Development Facilitation Team (DFT) – Review Comments

Application For: SD-2024-00048 – PRELIMINARY/FINAL PLAT

PR-2021-005606

CSI – CARTESIAN SURVEYS, INC. agent for **BARRY GLASS EDUCATIONAL FOUNDATION** requests the aforementioned action(s) for all or a portion of: **LOTS 150-A and 150-B, TOWN OF ATRISCO GRANT, UNIT 6** zoned **R-T**, located at **6800 GONZALES RD SW** between **AIRPORT DR SW** and **ADRIAN ST SW** containing approximately **5.6498** acre(s). (**K-10**)

**C-101**

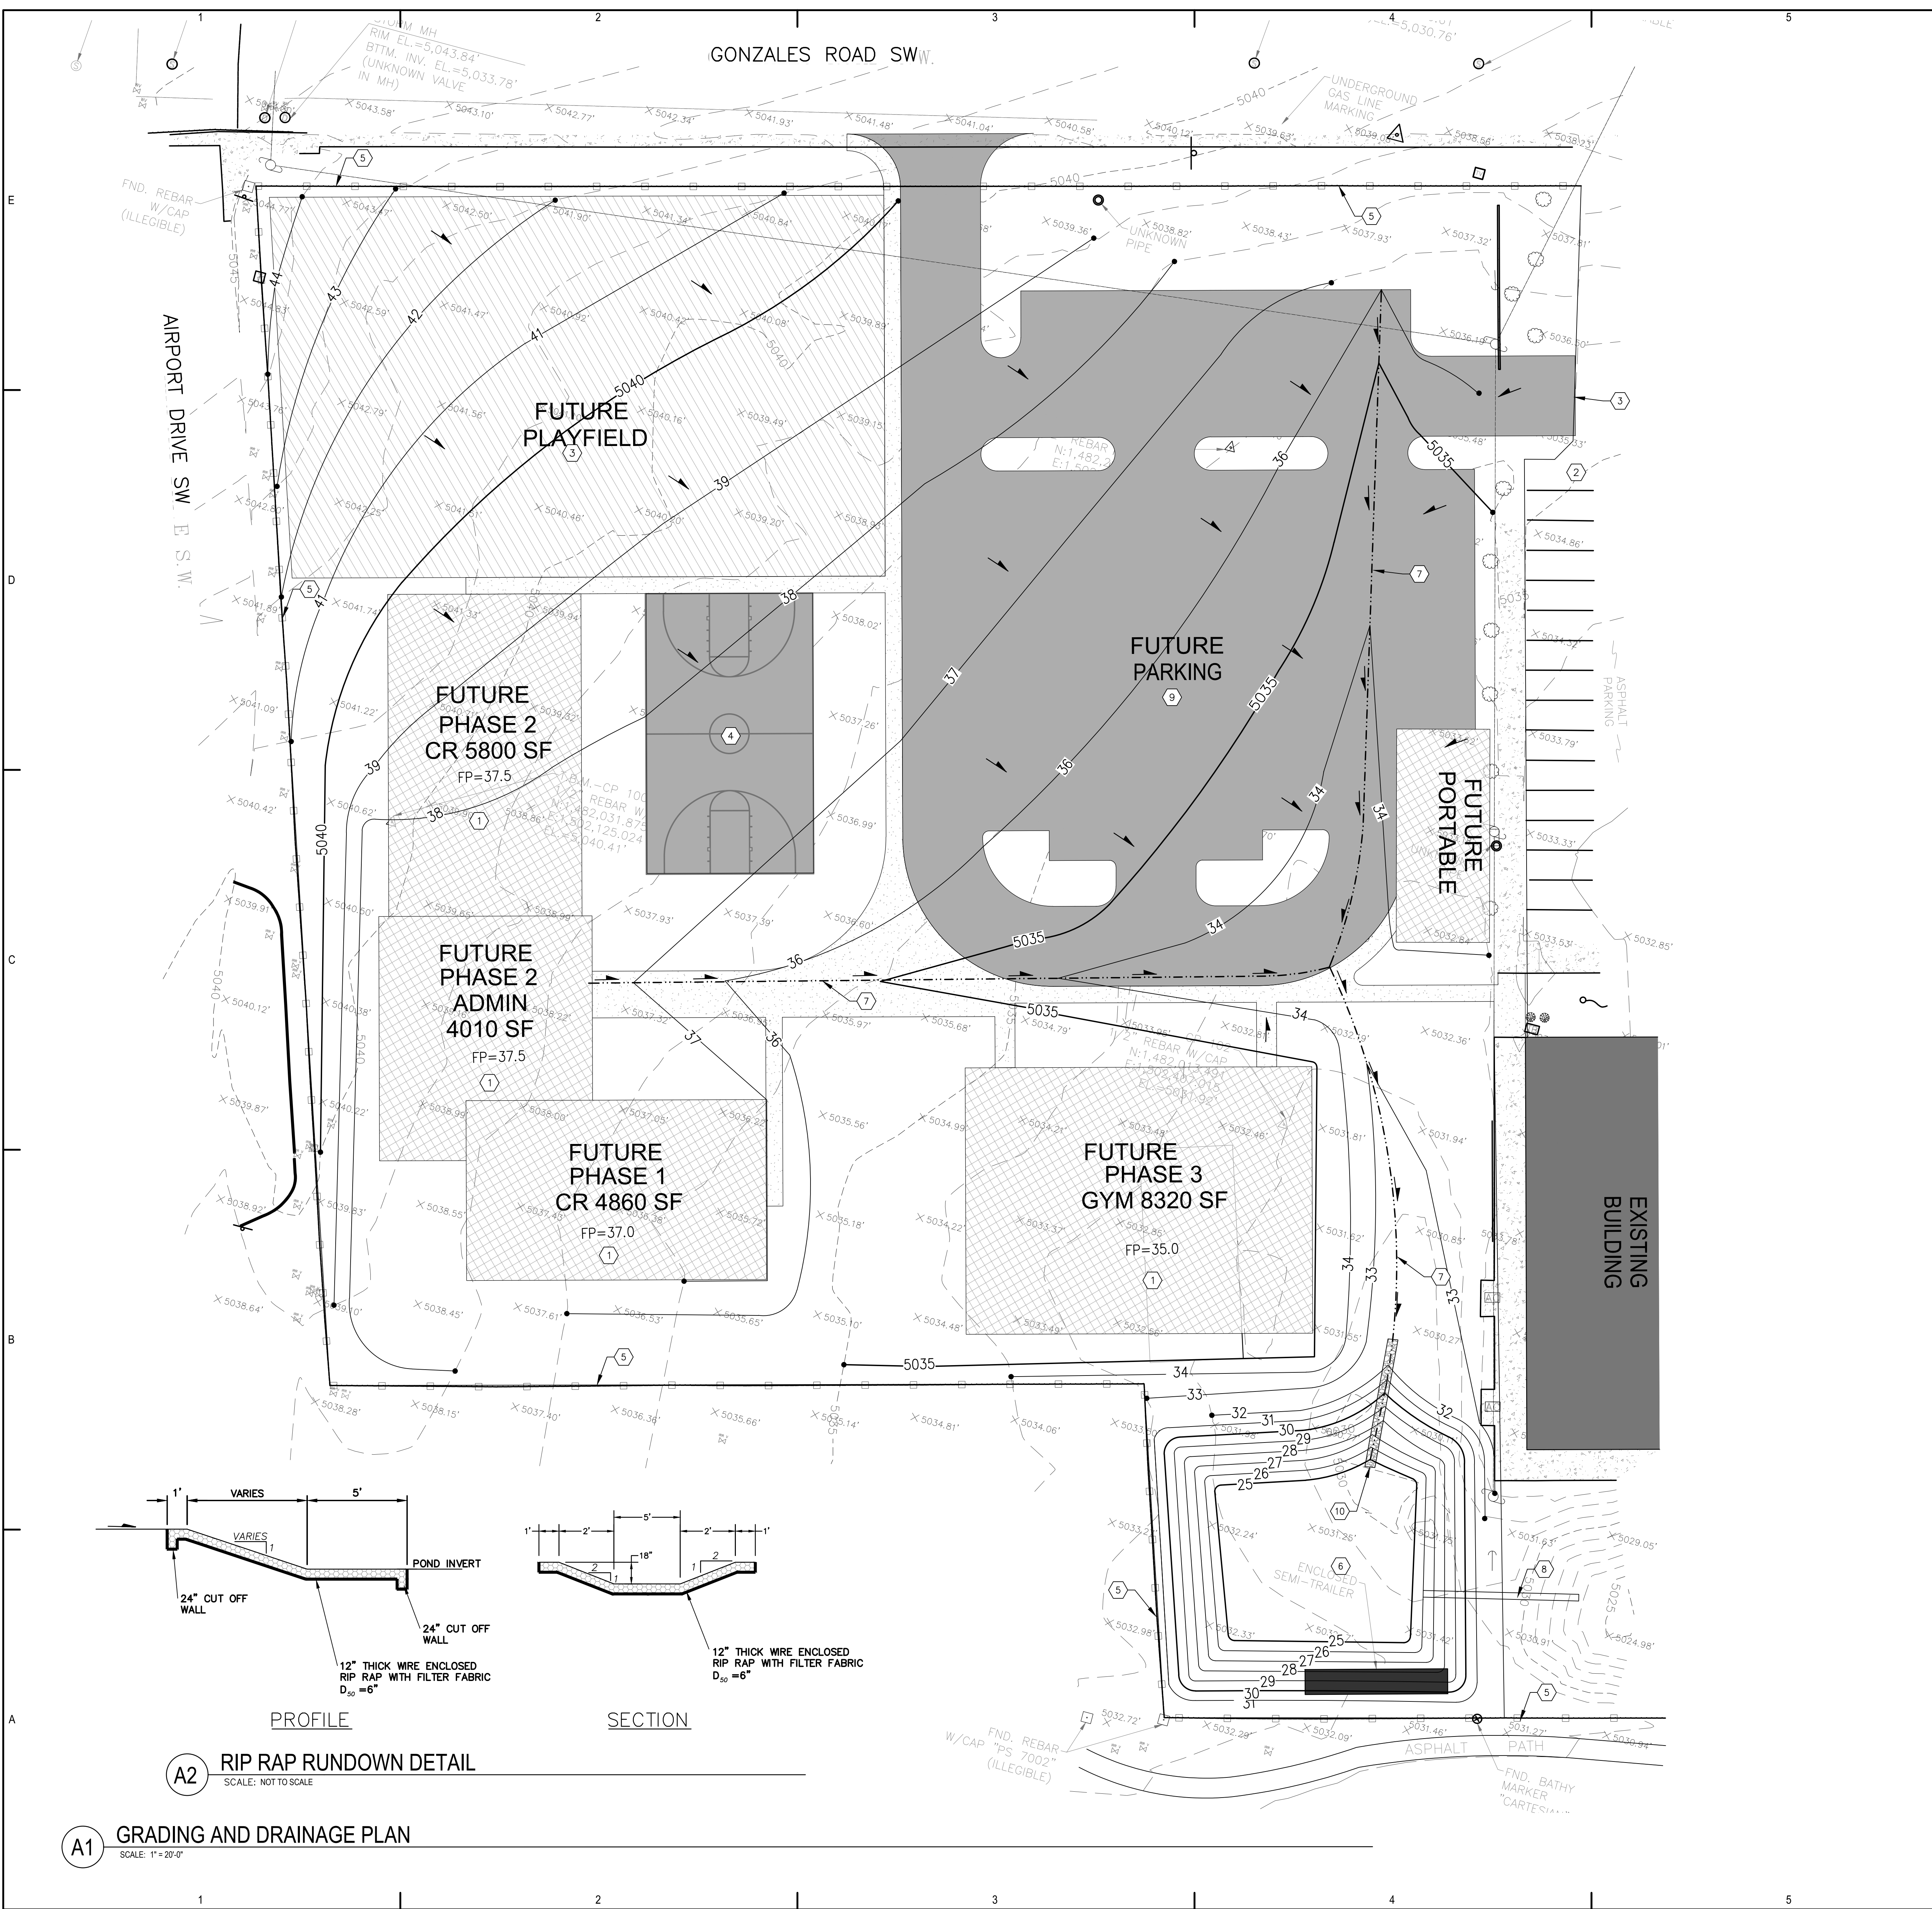
- Hydrology has an approved Grading & Drainage Plan (L10D007A) with engineer's stamp 11/11/2020.
- Hydrology has no objection to the platting action.
- **Comment** - Prior to submitting for Building Permit, a licensed New Mexico civil engineer will need to submit a Grading & Drainage Plan to Hydrology for review & approval if one of these conditions is met. (500 cy of grading, 1,000 sf of proposed building, or 10,000 sf of proposed paving). Please note that this site's discharge has to obtain the 100 year – 10-day volume in a retention pond, since there is no downstream capacity.

SHEET TITLE  
**OVERALL SITE PLAN**

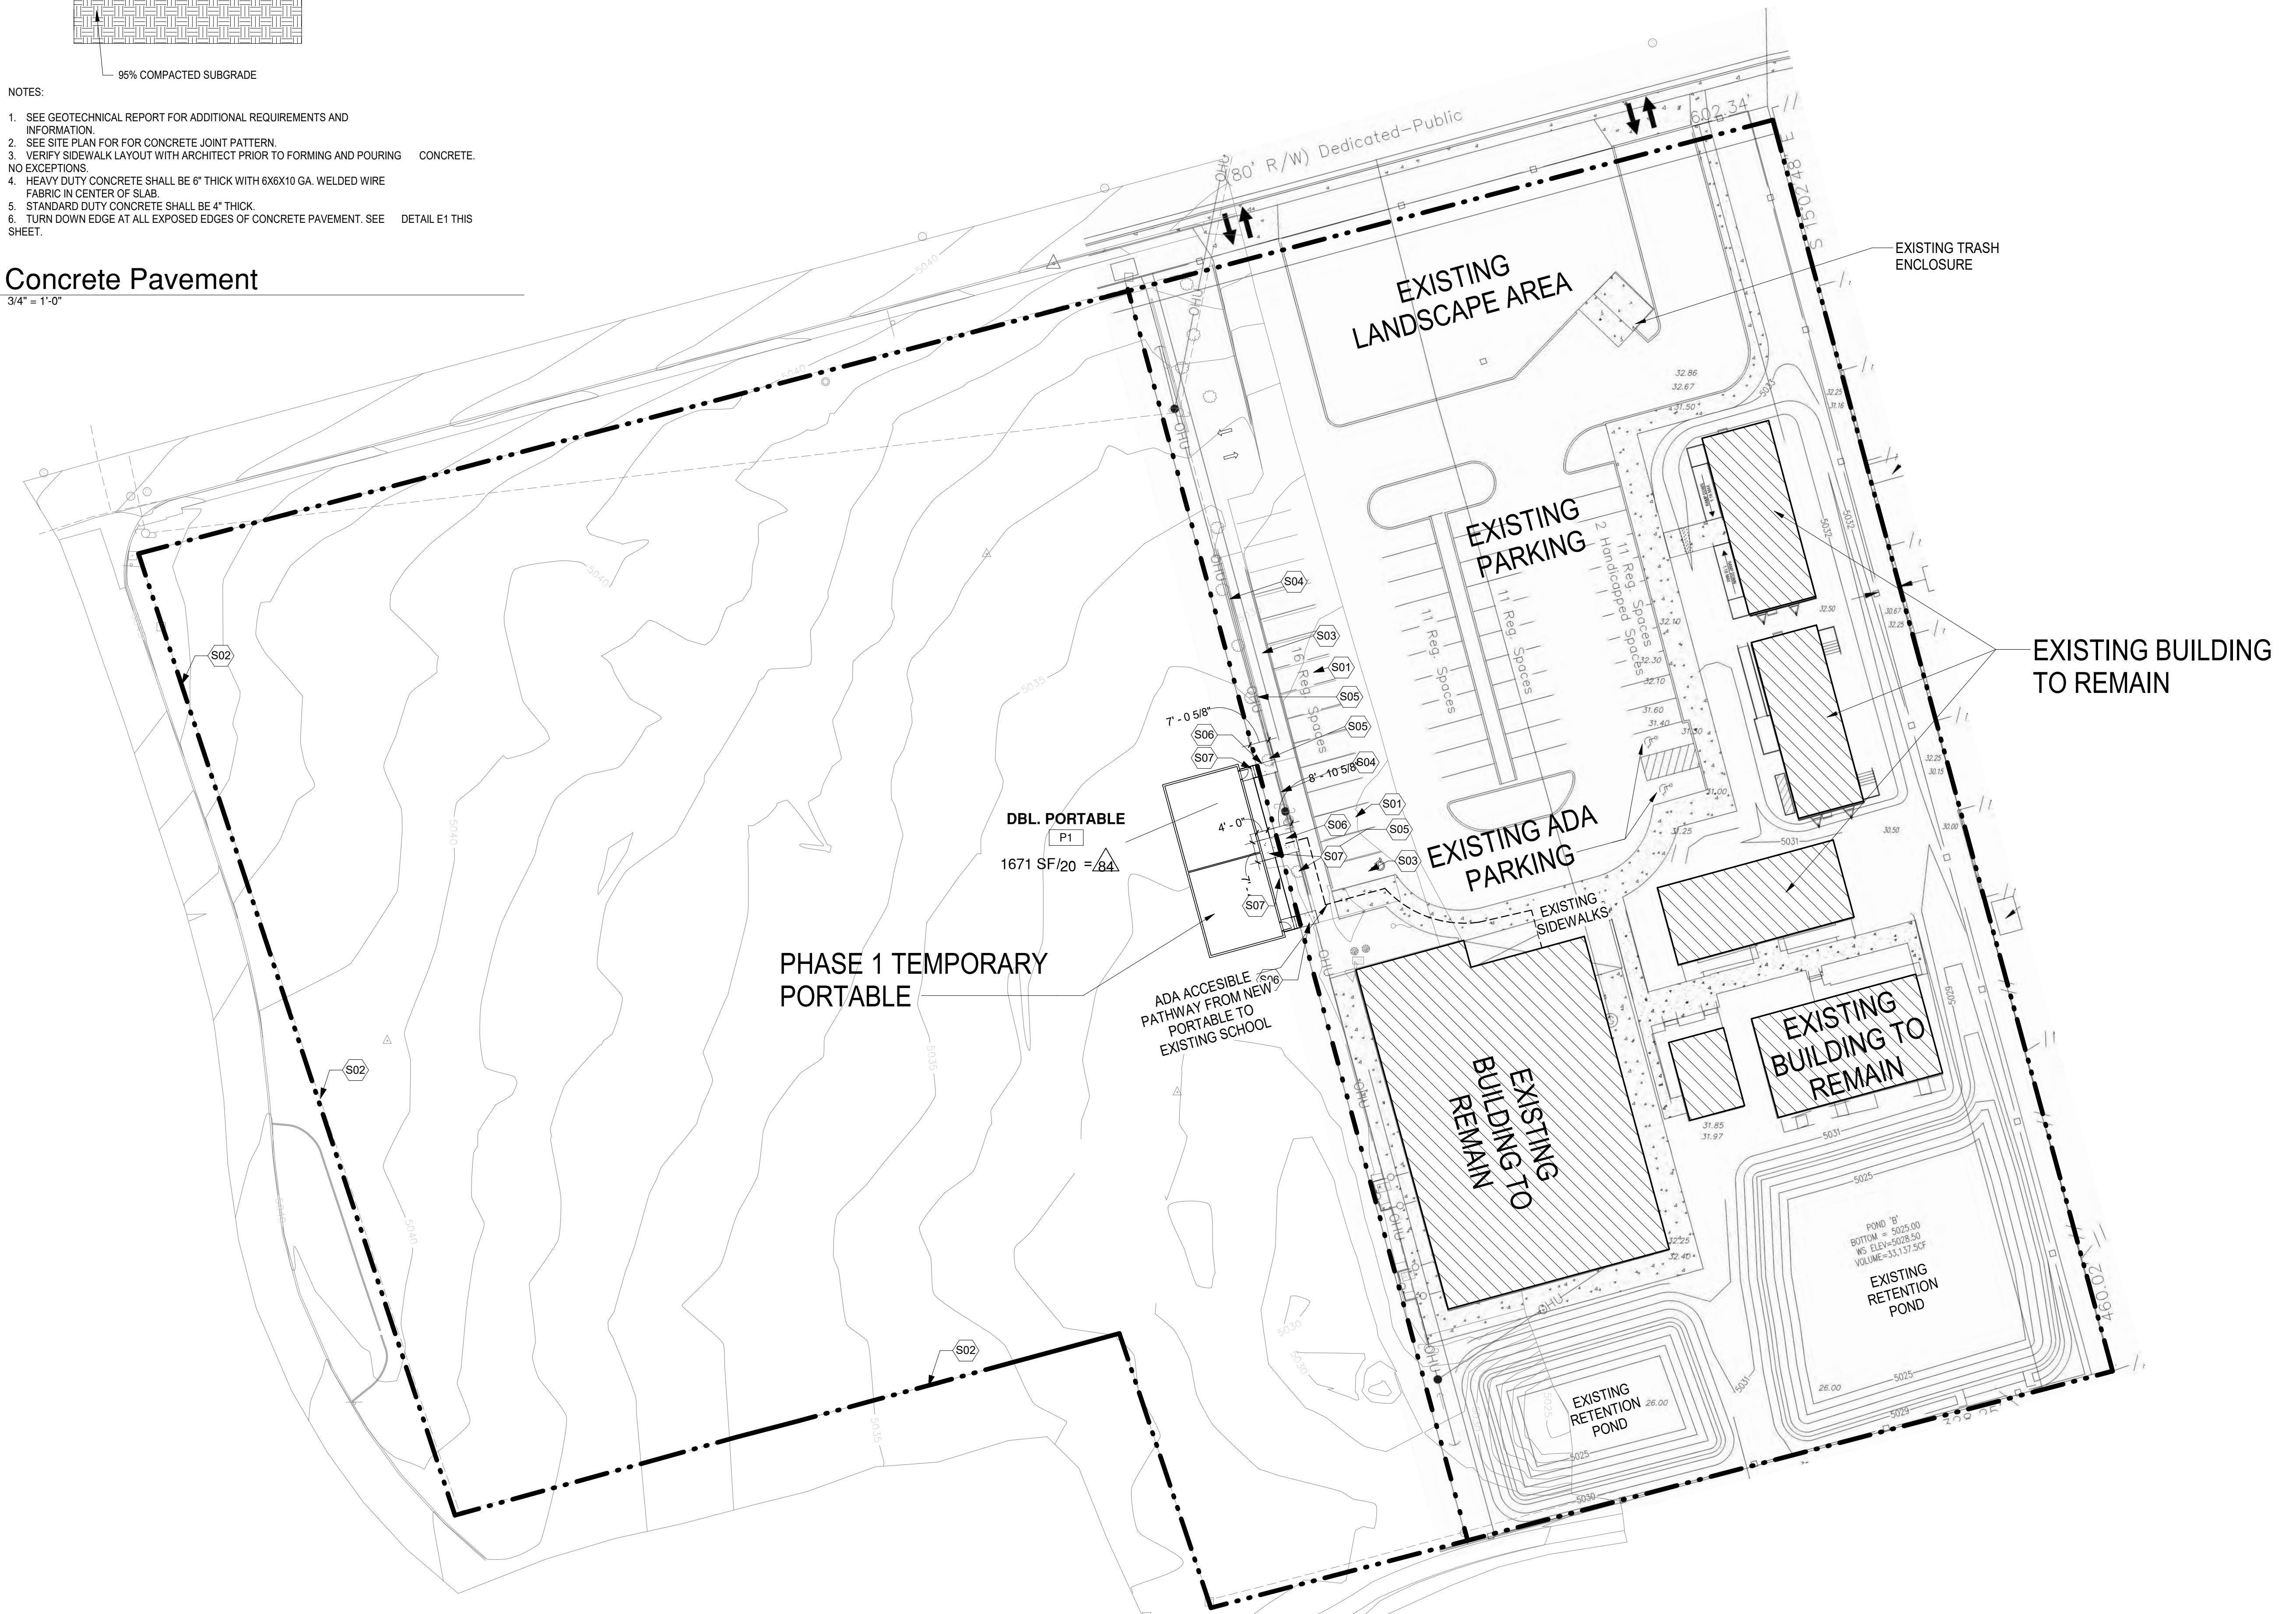
1. Coors is a Principal Arterial and a major transit corridor and requires 6' to 10' sidewalk with a 6' to 8' sidewalk. Gonzales is a local road and requires 5' sidewalk with 4' to 6' landscape buffer. All work in the ROW needs to be placed on an infrastructure list.
2. For future development, an approved TCL will be required before site plan or building permit. Also, a Traffic Scoping Form will need to be submitted to Matt Grush (mgrush@cabq.gov) to determine if a TIS will be required.

- Demonstrate compliance with section 7 of the DPM Table 7.2.29 and Required Improvements section from 5-4(N) of the IDO. In regards to the Sidewalk width requirements and the accompanying landscape buffer.
Verification of standards per Transportation
Provide measurement for the existing ROW and distance from curb to property line along street frontage.

- Gonzales Street is considered a local street and requires a 5-foot side walk and 4-6-foot landscape buffer. Please clarify regarding the landscape buffer size.
- The application number must be added to the Plat.
- Please explain what use is being proposed for future development on this site.
- Per 6-6(K)(2)(k), The date of the DHO approval shall be recorded on the Final Plat, and verification of compliance with conditions of approval shall be dated and verified by the signatures of the required commenting agencies pursuant to Subsection 14-16-6-4(J)(2).
- After acceptance of the Plat application, DXF approval from AGIS must be obtained.
- After DHO approval and final sign off, a **recorded copy of the plat must be sent to the Jay Rodenbeck** at jrodenbeck@cabq.gov and **Angela Gomez** at agomez@cabq.gov (should the Plat be approved by the DHO).
